Householder Proforma

Application Ref: 2021/0942
Address: 32 School Street, Darfield, Barnsley, S73 9ET
Neighbour Representations: No
Consultations: Highways – no comments received
Property Description: the link detached property is located in a predominantly residential area, within a row of similar dwellings of varying styles. The dwelling benefits from a parking area to the front of the property and occupies a modest plot with open green space beyond the rear boundary.

Proposed Extension: Erection of a first floor side extension, and two storey and single storey rear extensions.
UDP Designation: Housing Policy Area
Local Plan Designation: Urban Fabric
Conservation Area: No
Relevant History: N/A
Acceptable in Principle: Yes

Drawing Title
PROPOSED LAYOUTS

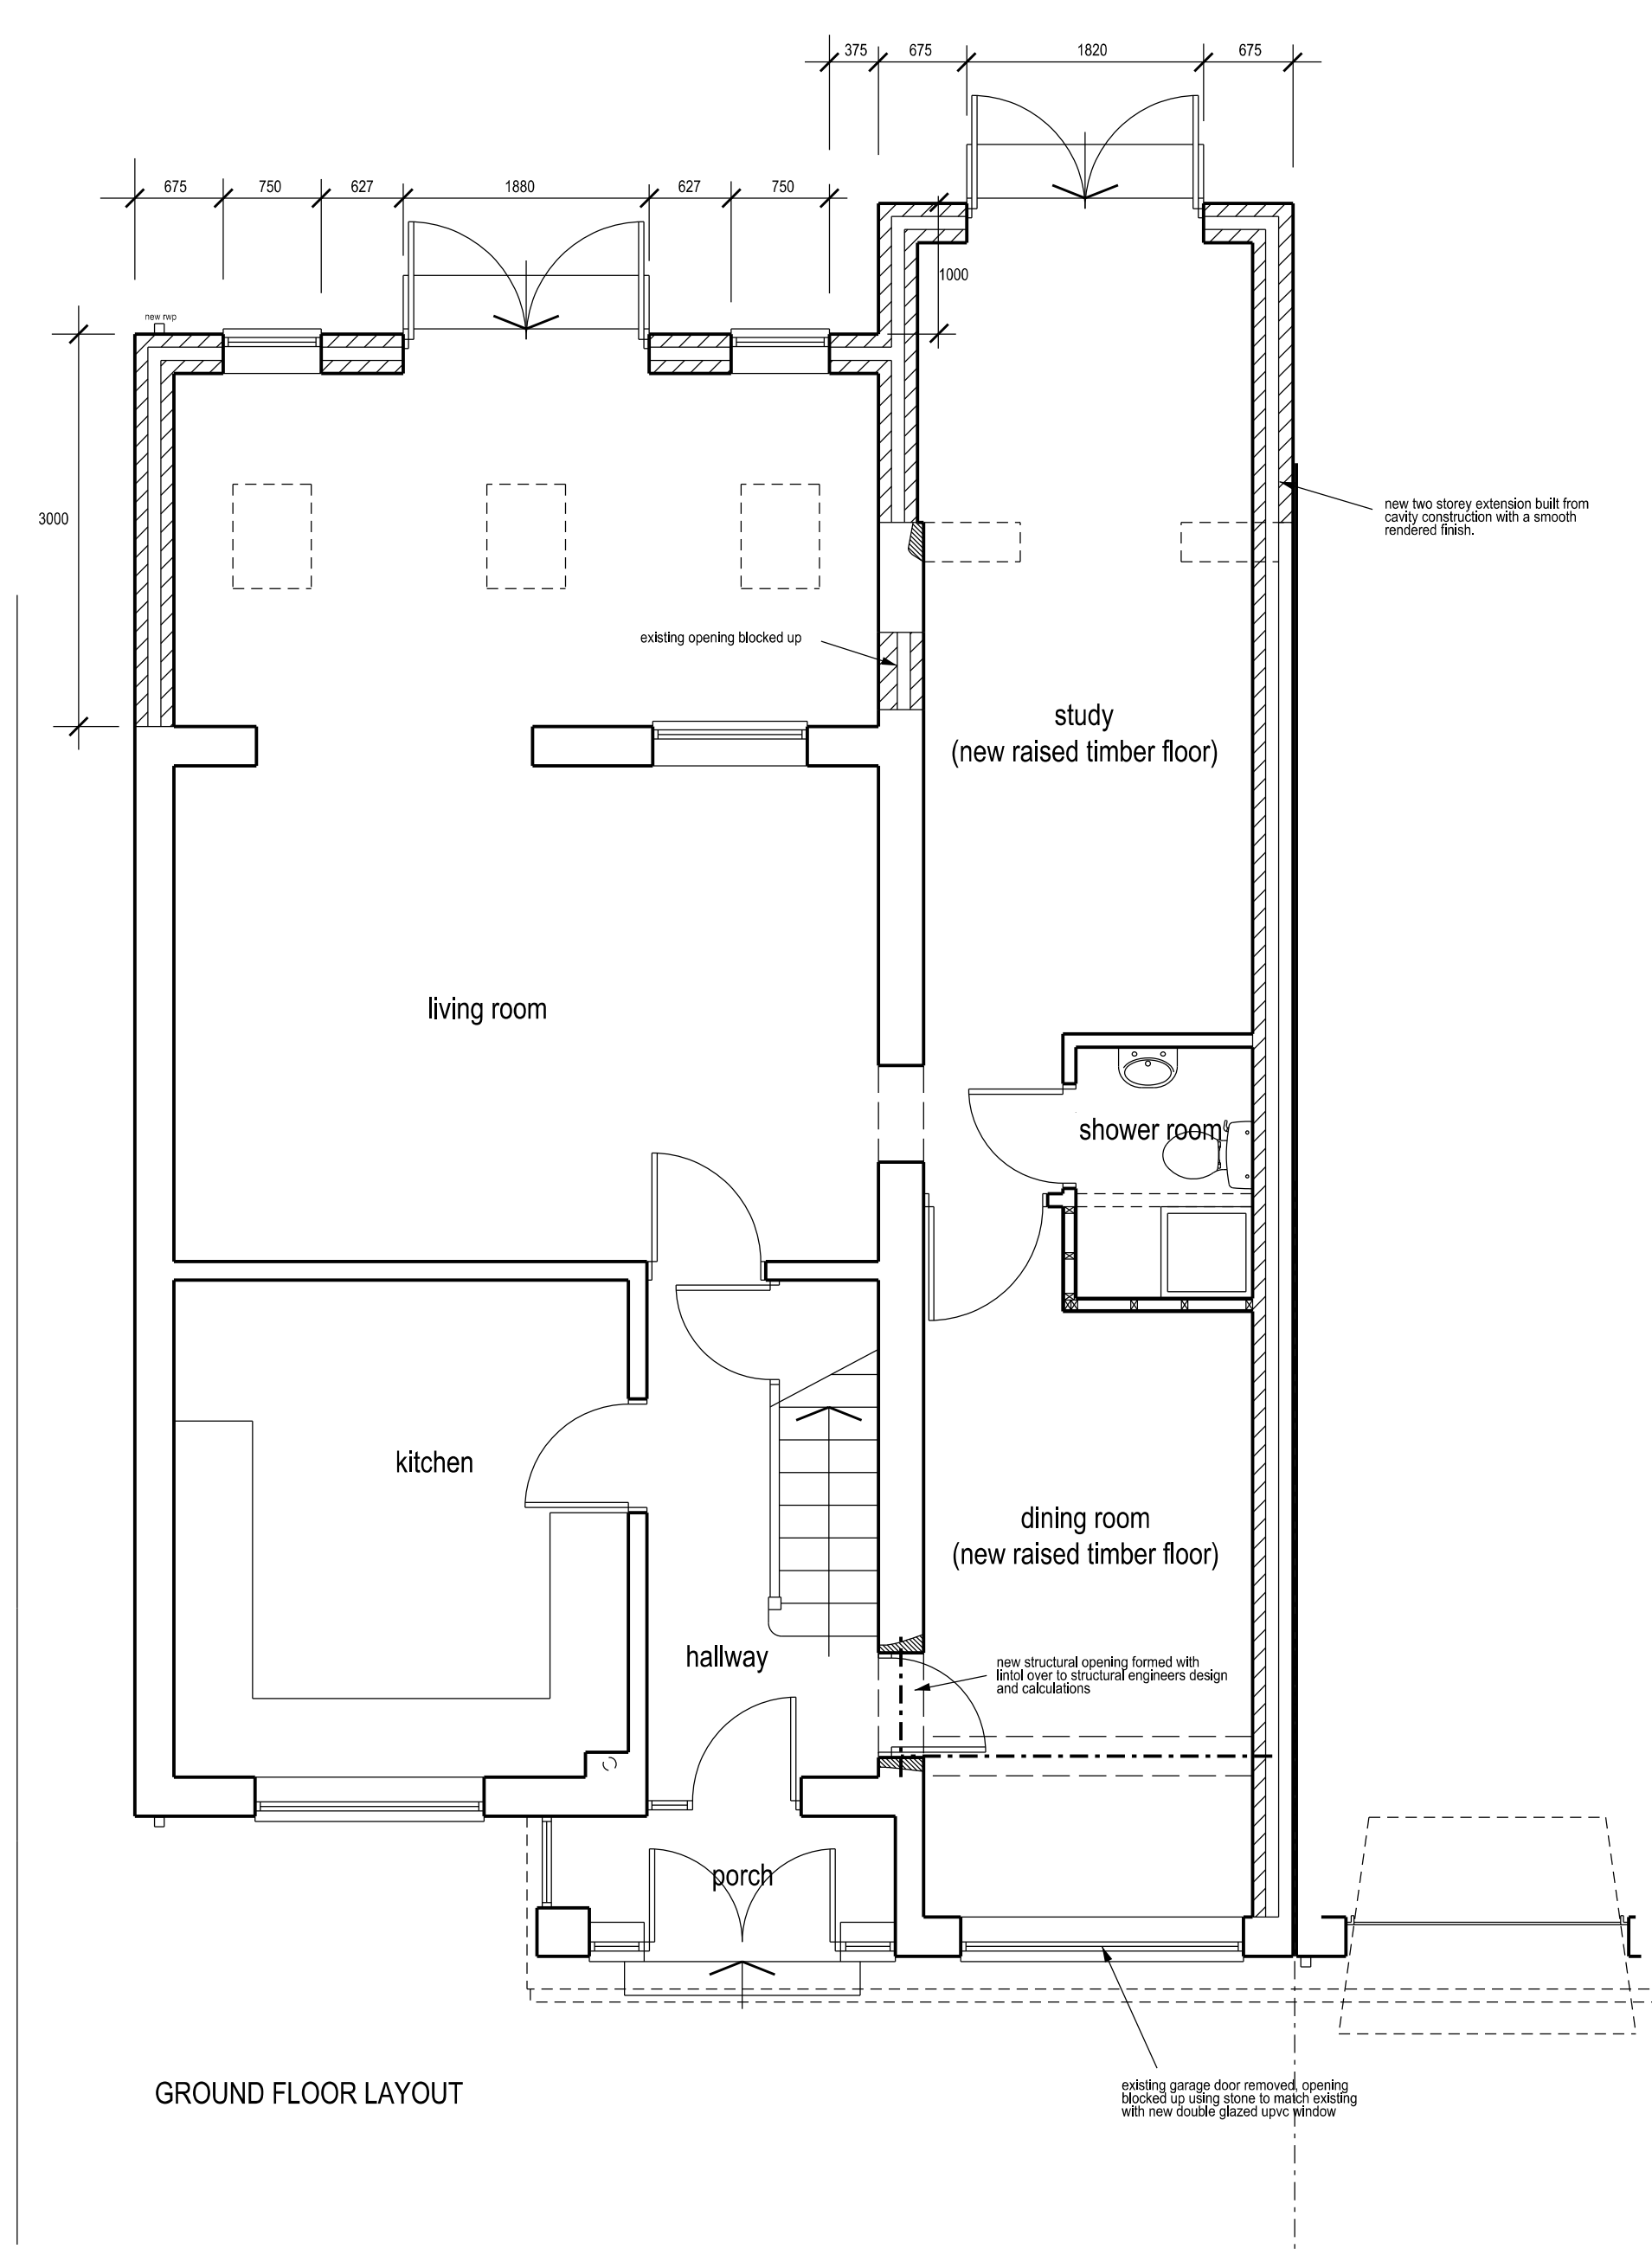
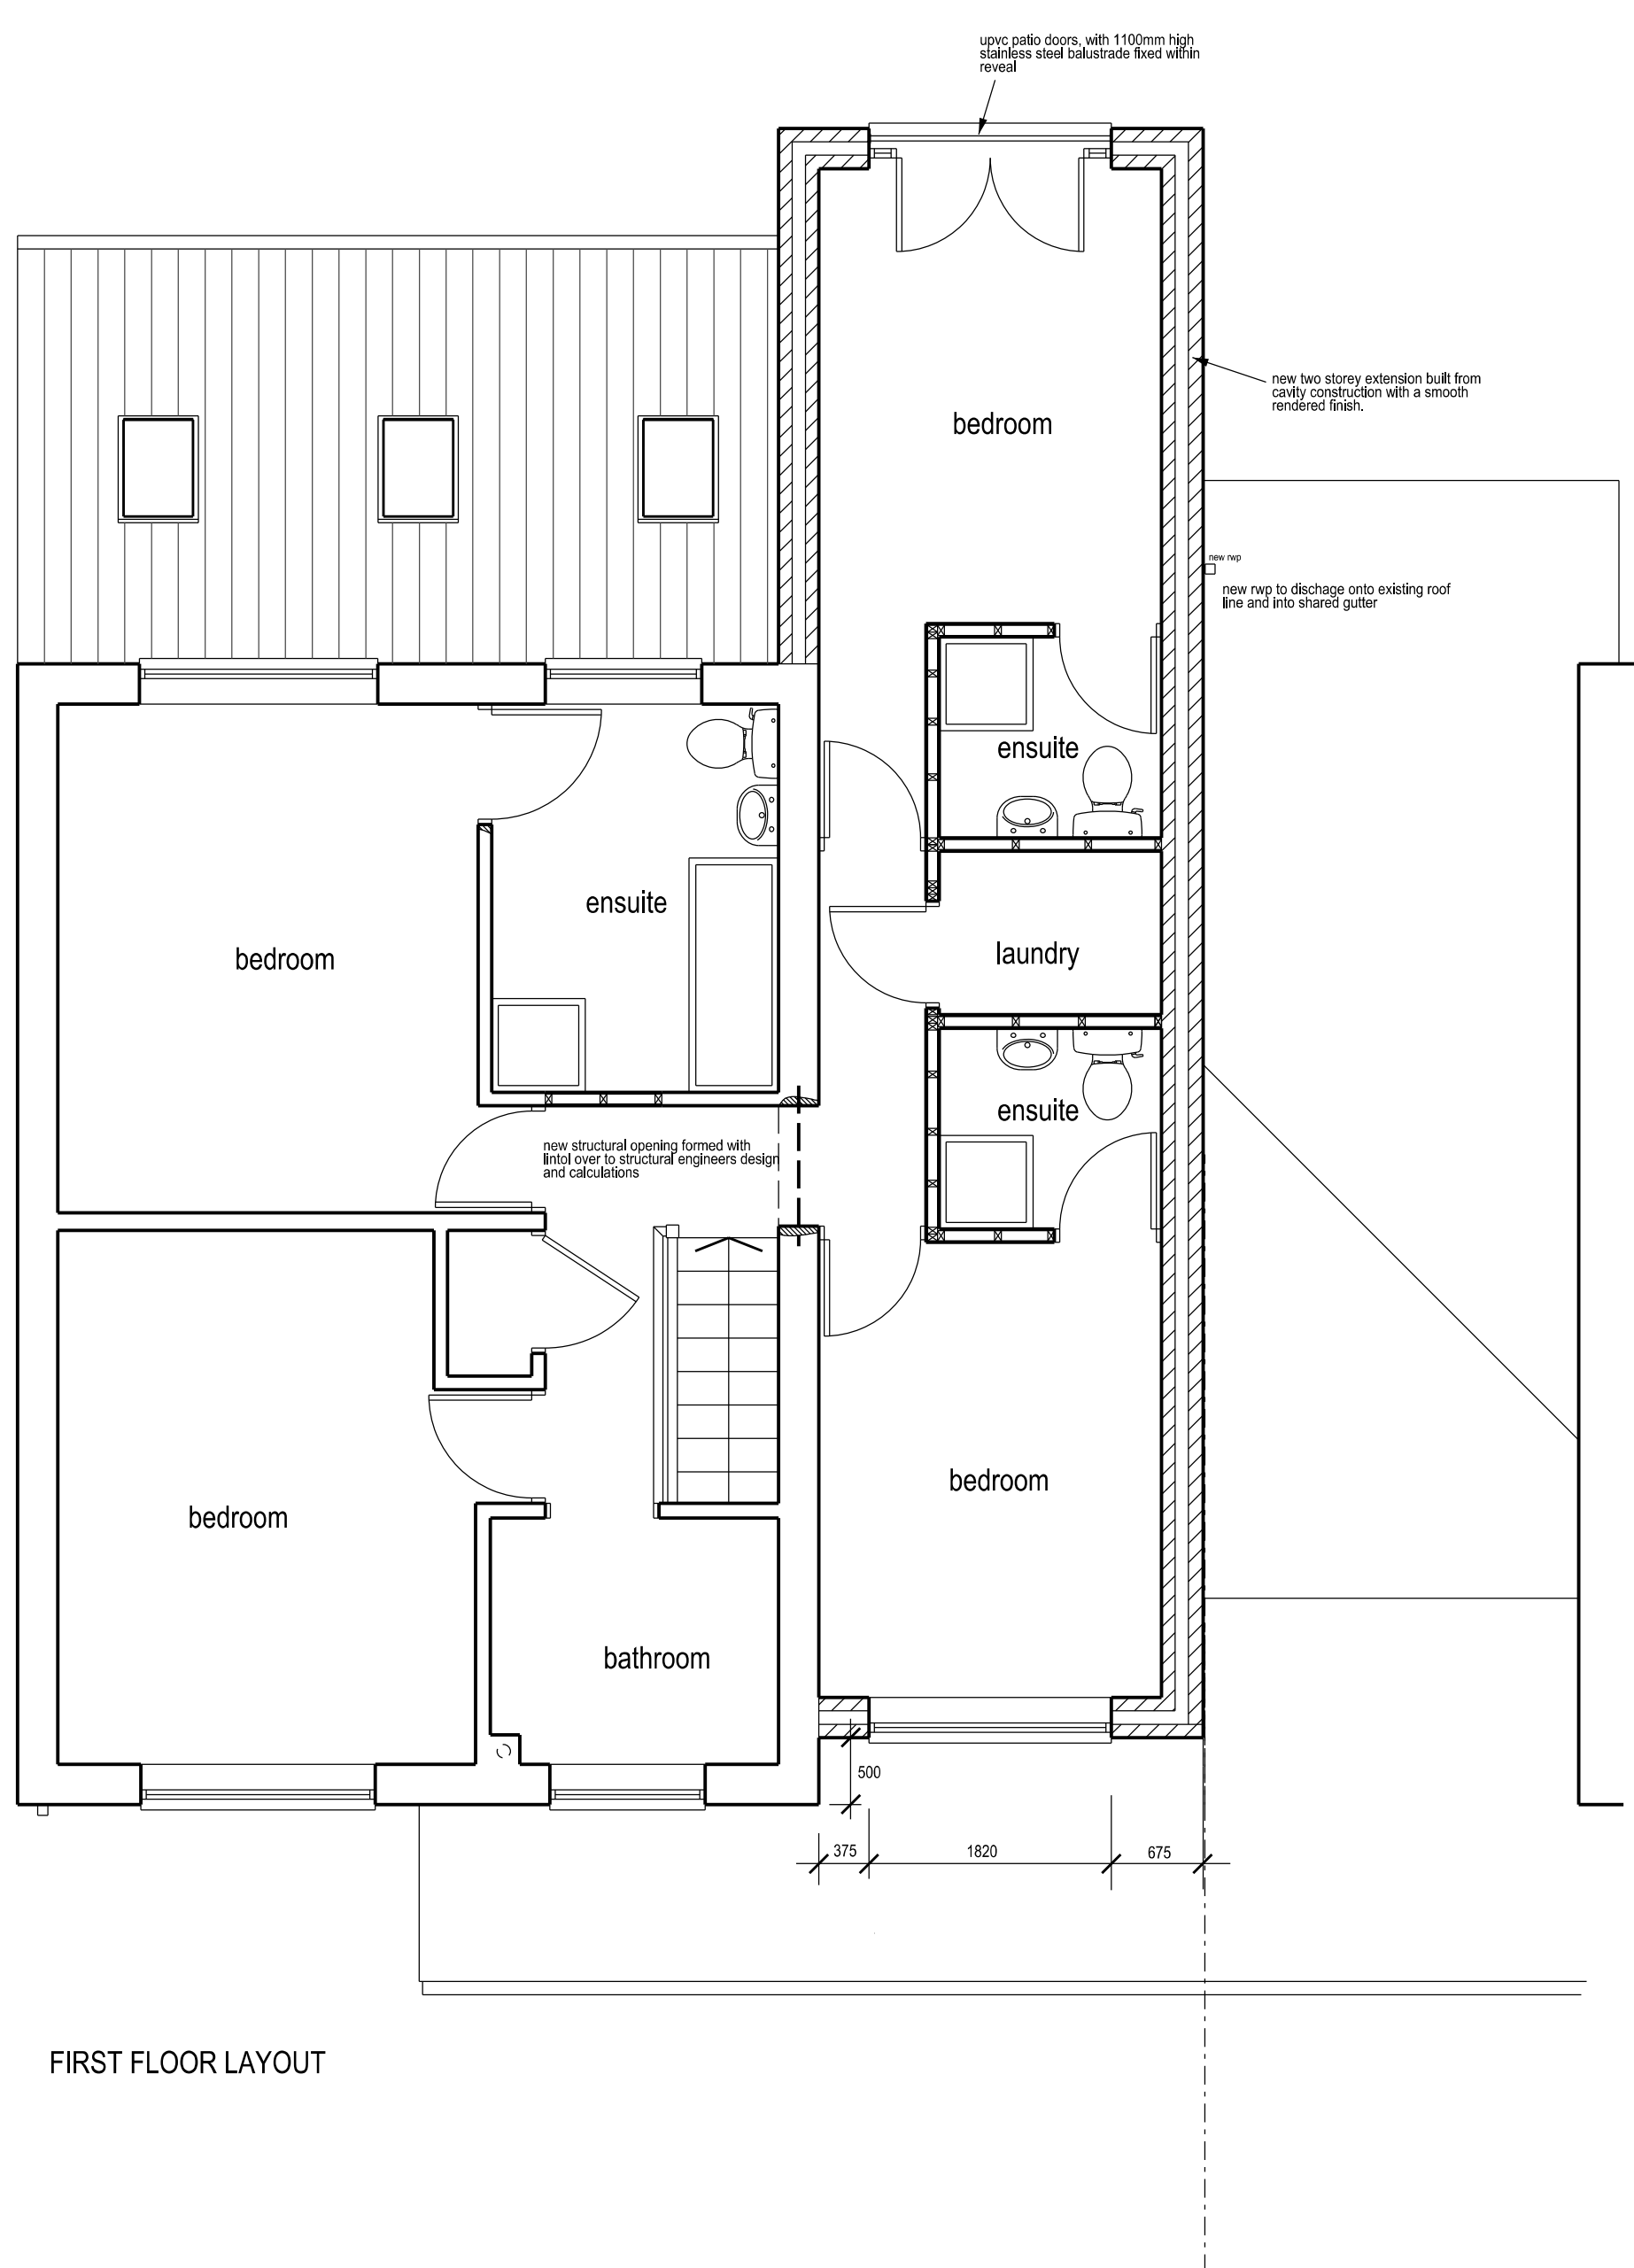
The single storey rear extension is to be located adjacent to the boundary with the property to the north, 30 School Street, whilst the extension is attached to the two storey element, the single storey extension falls within the parameters of PD at 3m projection and could be erected under PD. It is not considered this element would have a detrimental impact on the amenity of the neighbouring dwelling.

The proposal sees the loss of the garage, however at 2.7m by 5.7m internally is not sufficient to be considered a parking space under current standards, however there is sufficient space to the front of the property to accommodate 2no vehicles.
